Town and Country Planning Act 1990 Refusal of Planning Permission

Reference: H16-0536-15 Received: 12th June 2015

Description: Proposed extensions including internal alterations to existing dwelling

Location : 12 HALMER GATE SPALDING

DRWG No. 420/2/2015^E

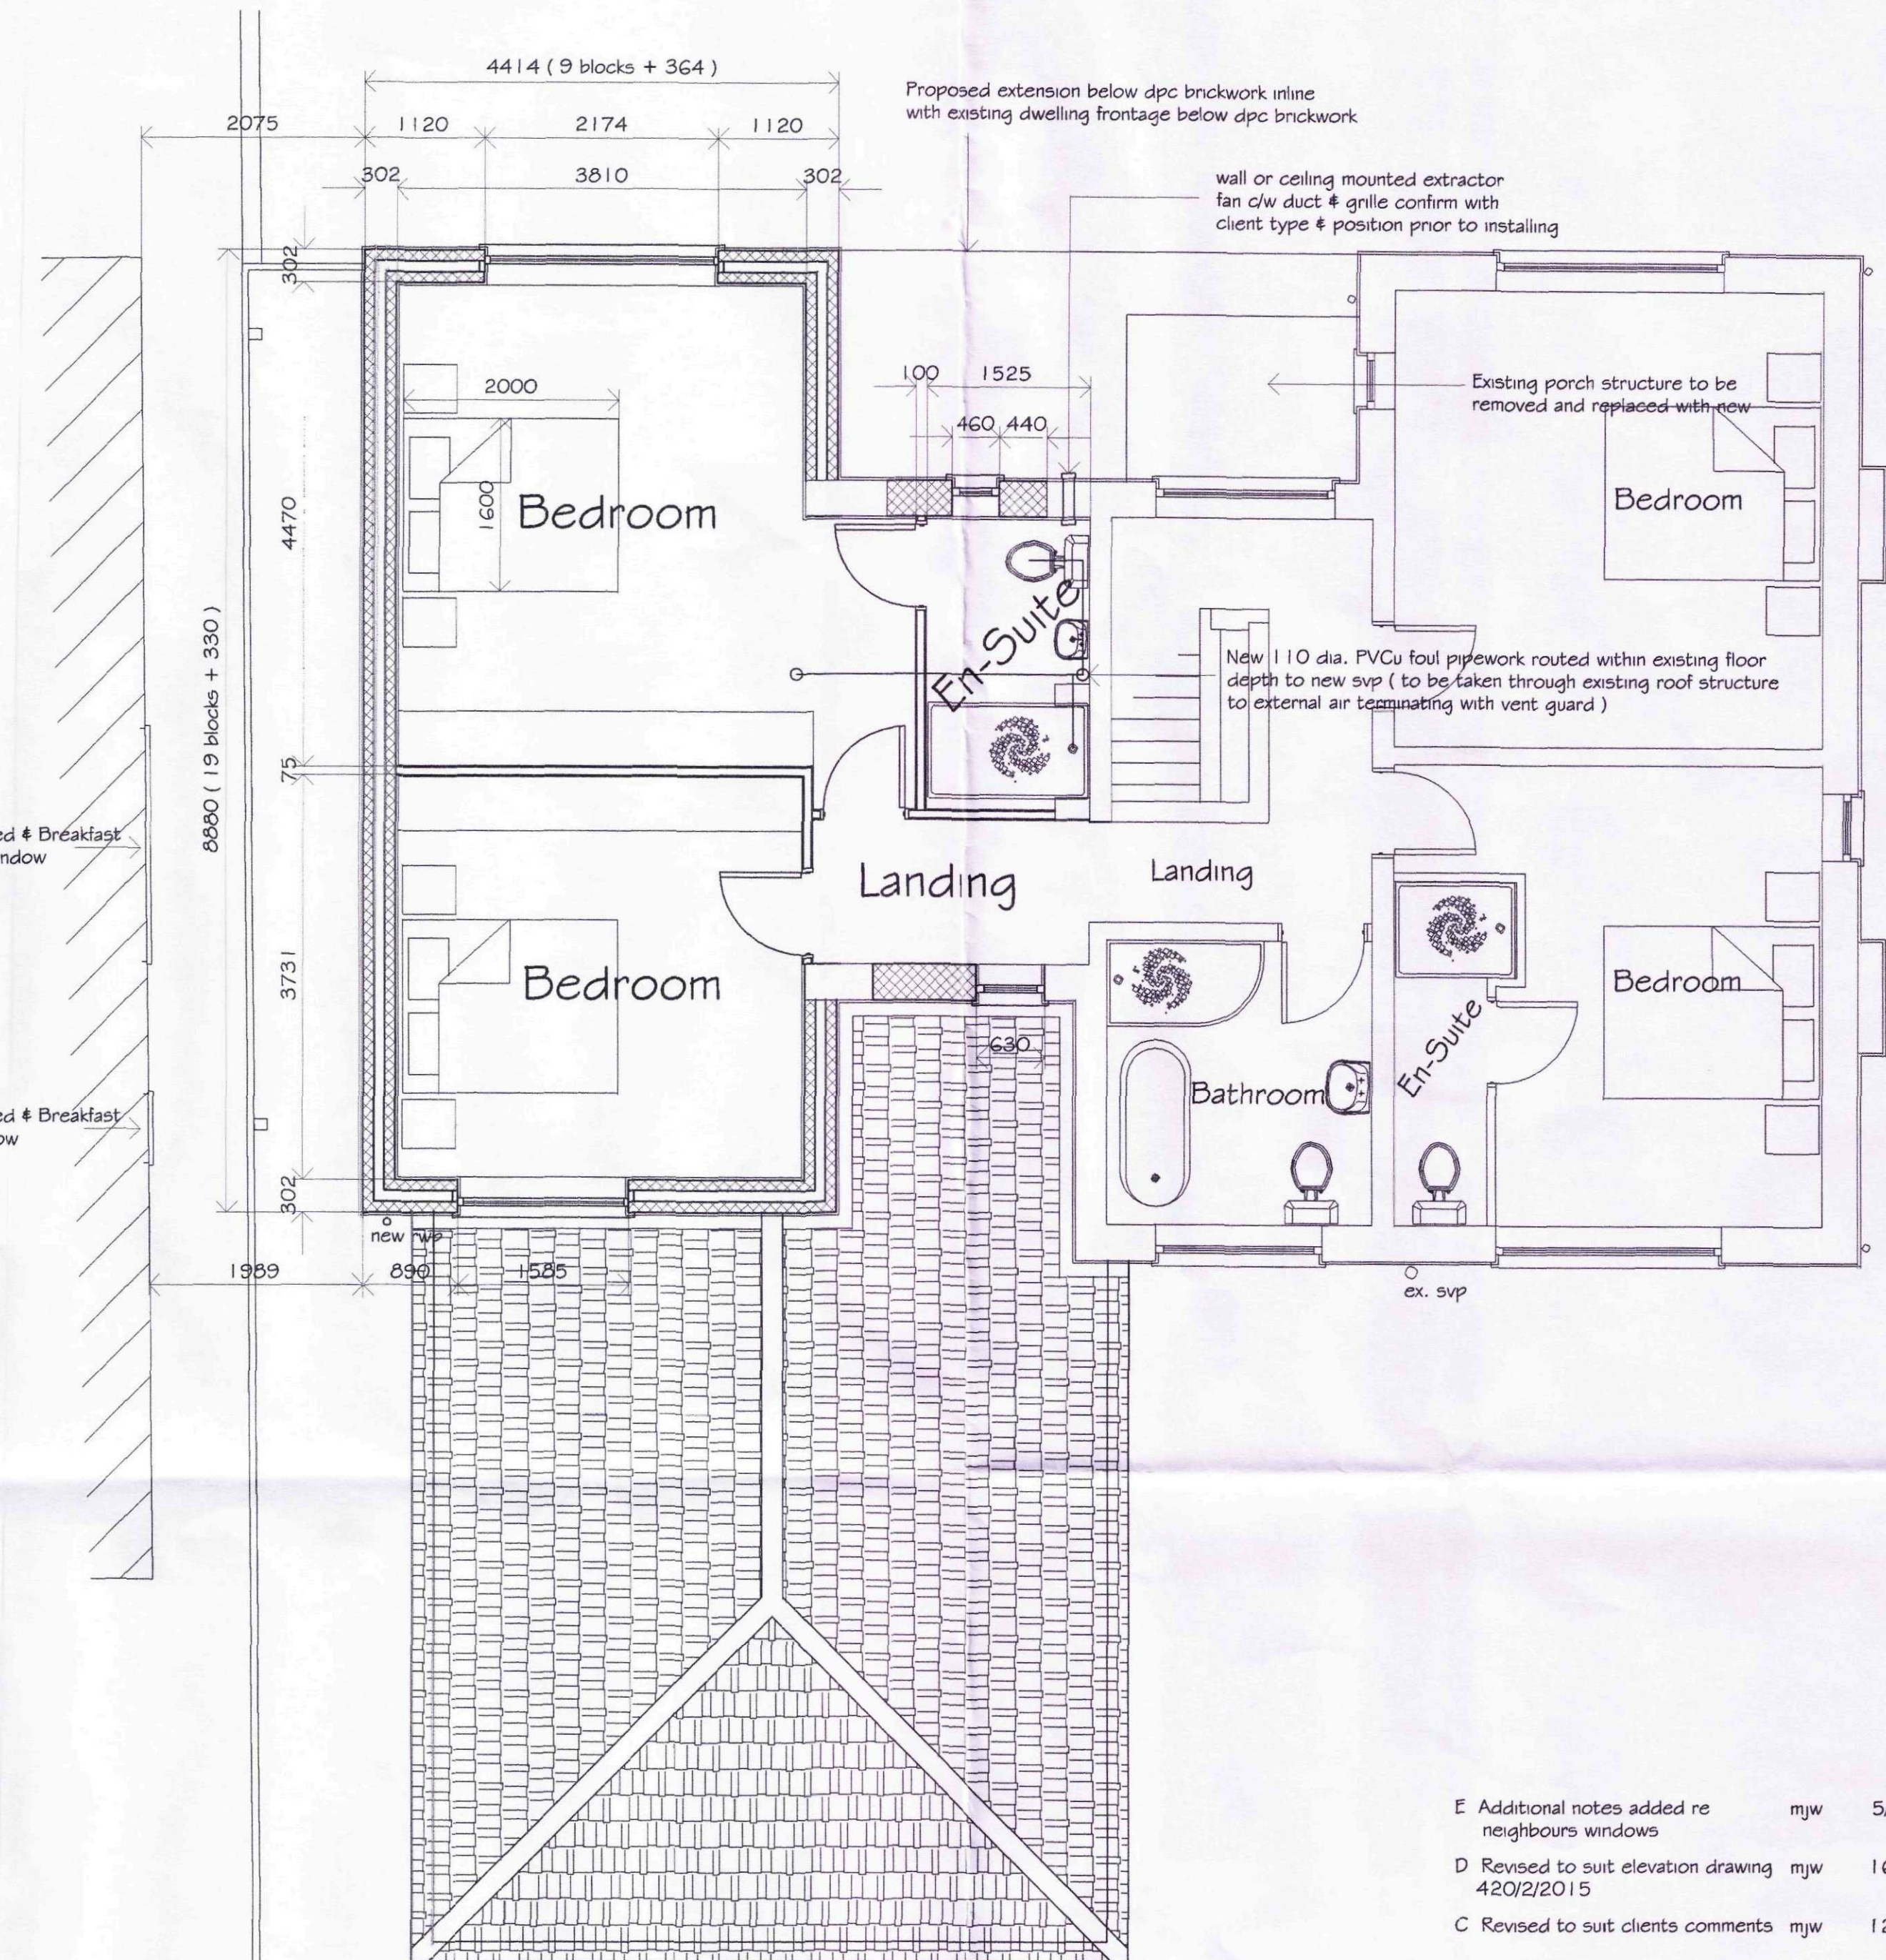
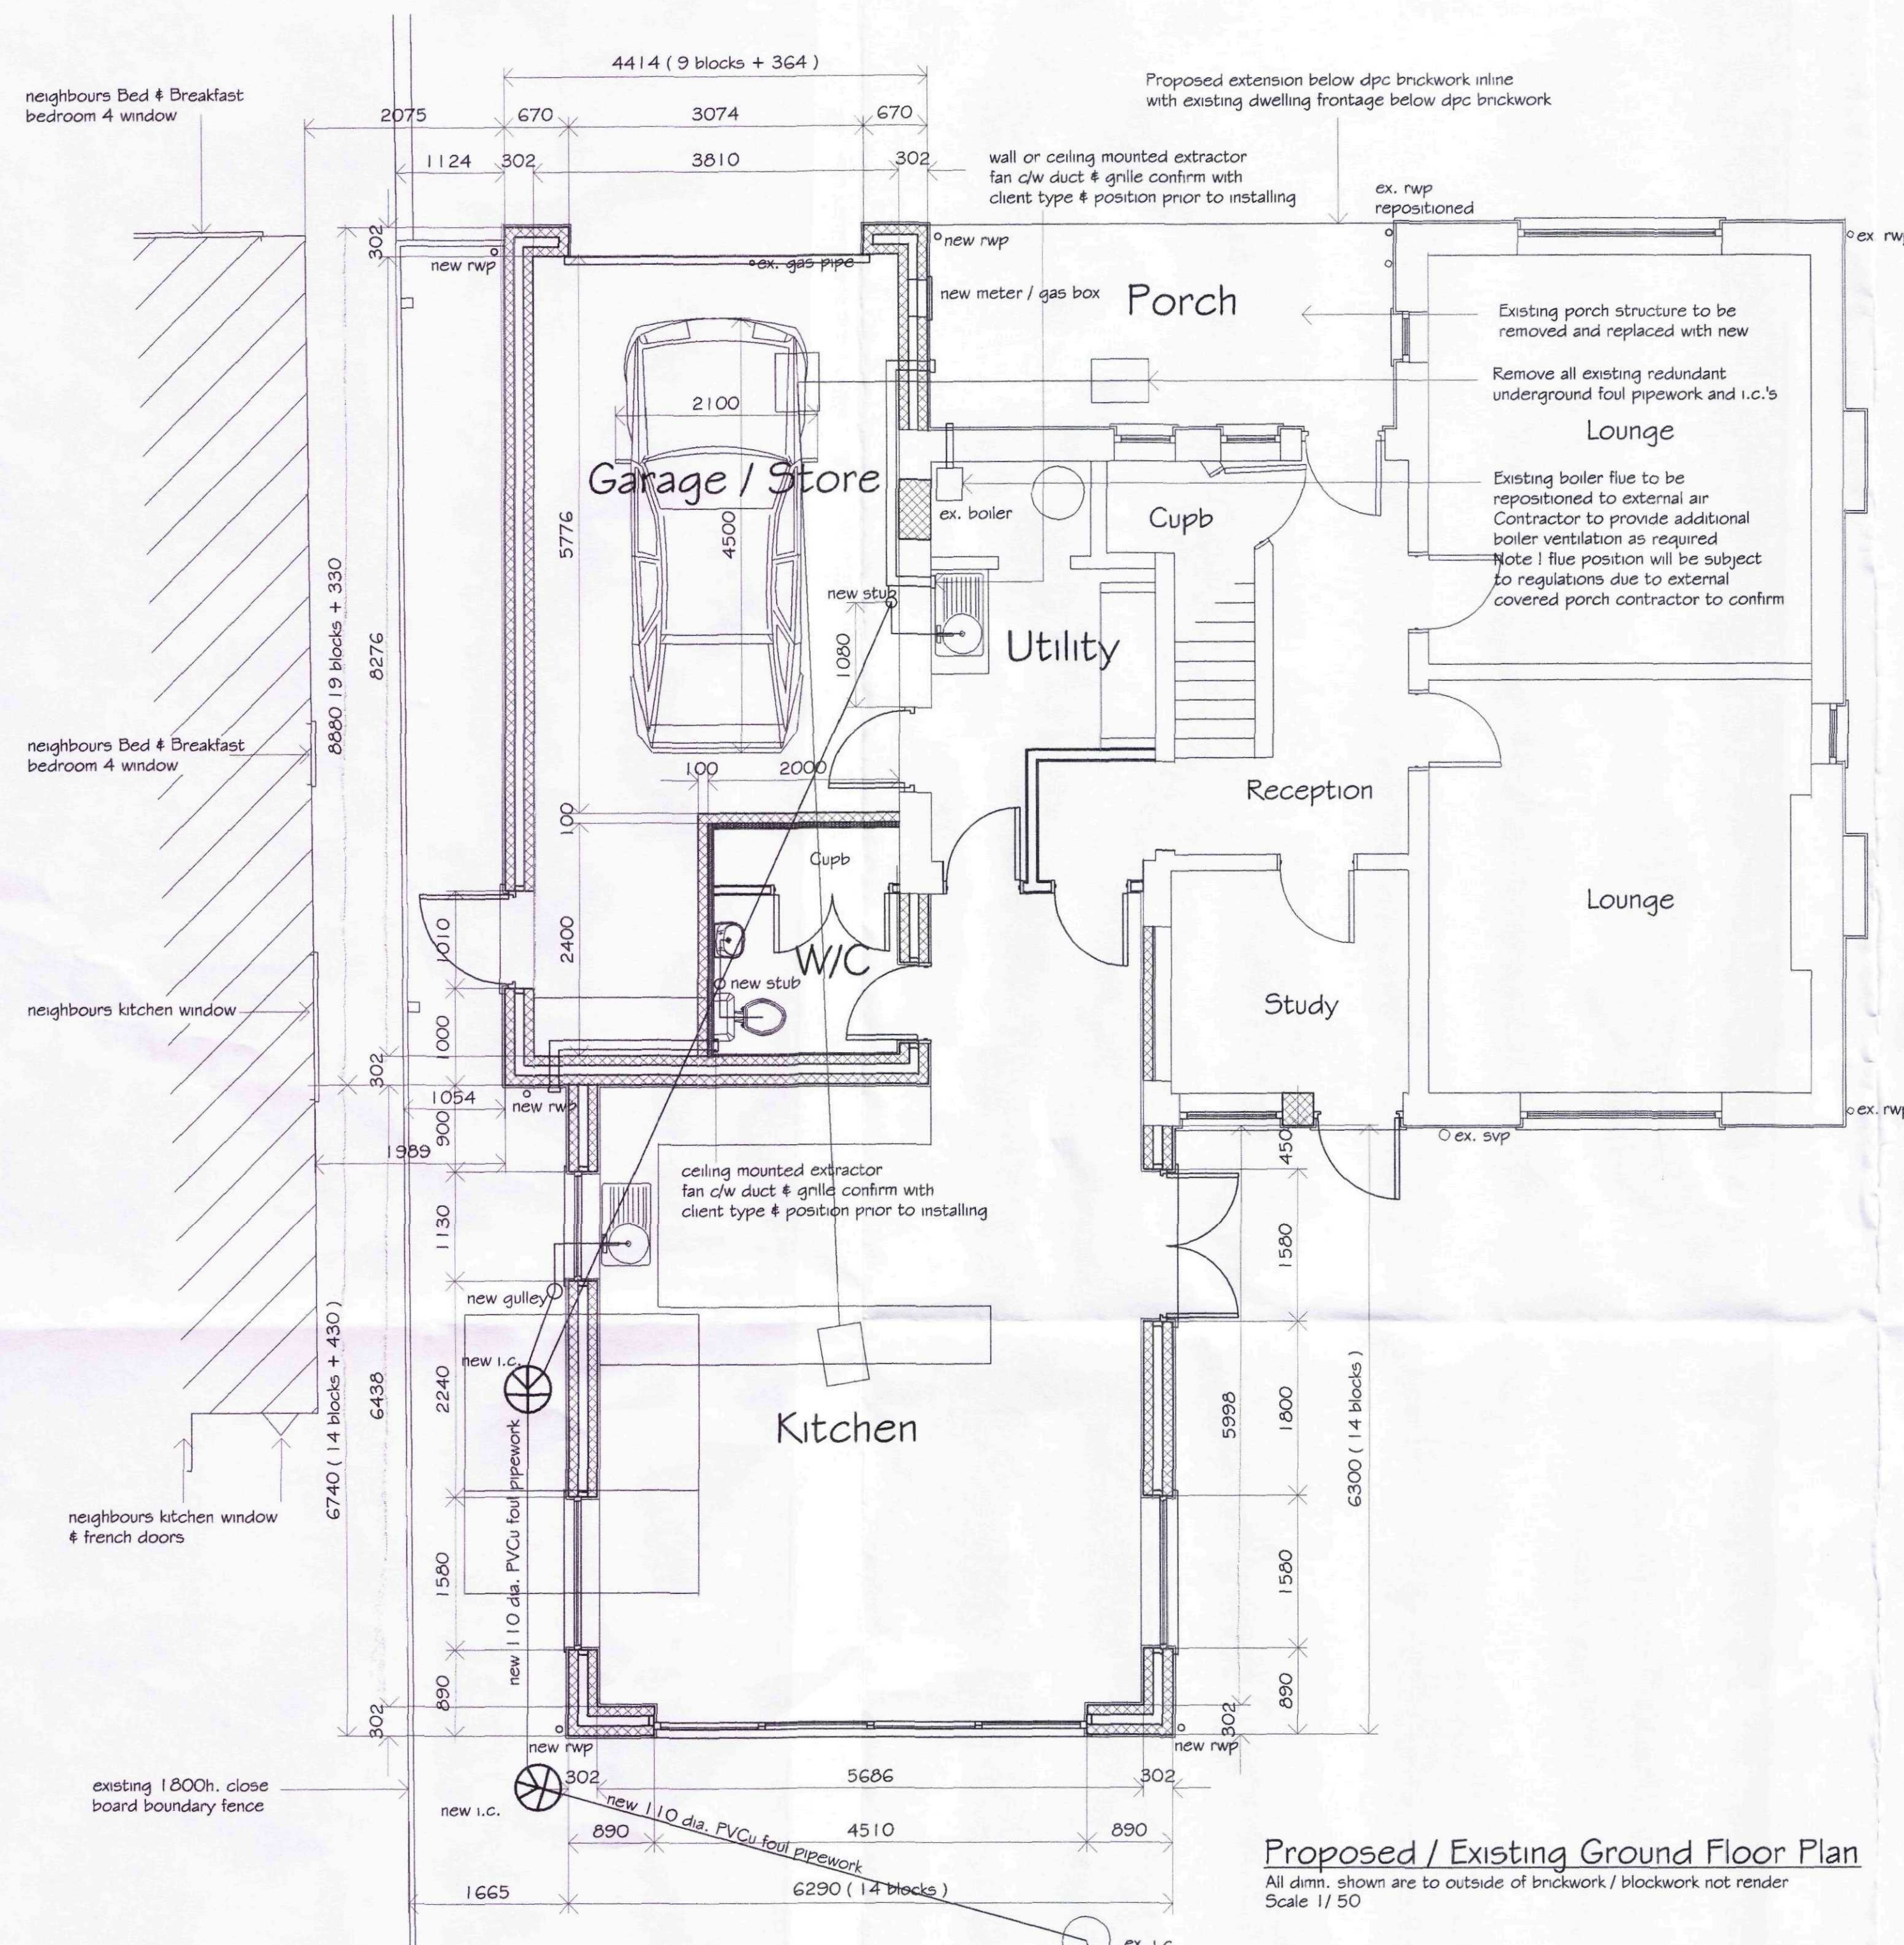
- 1 The proposal would lead to a substantial loss of light to the windows on the side elevation of the adjacent Guest House by virtue of the siting of a two-storey wall 1.9 metres from the existing window. This would be contrary to Policies SG1 and SG20 of the South Holland Local Plan, 2006. which seek to protect the amenities of adjacent residents.
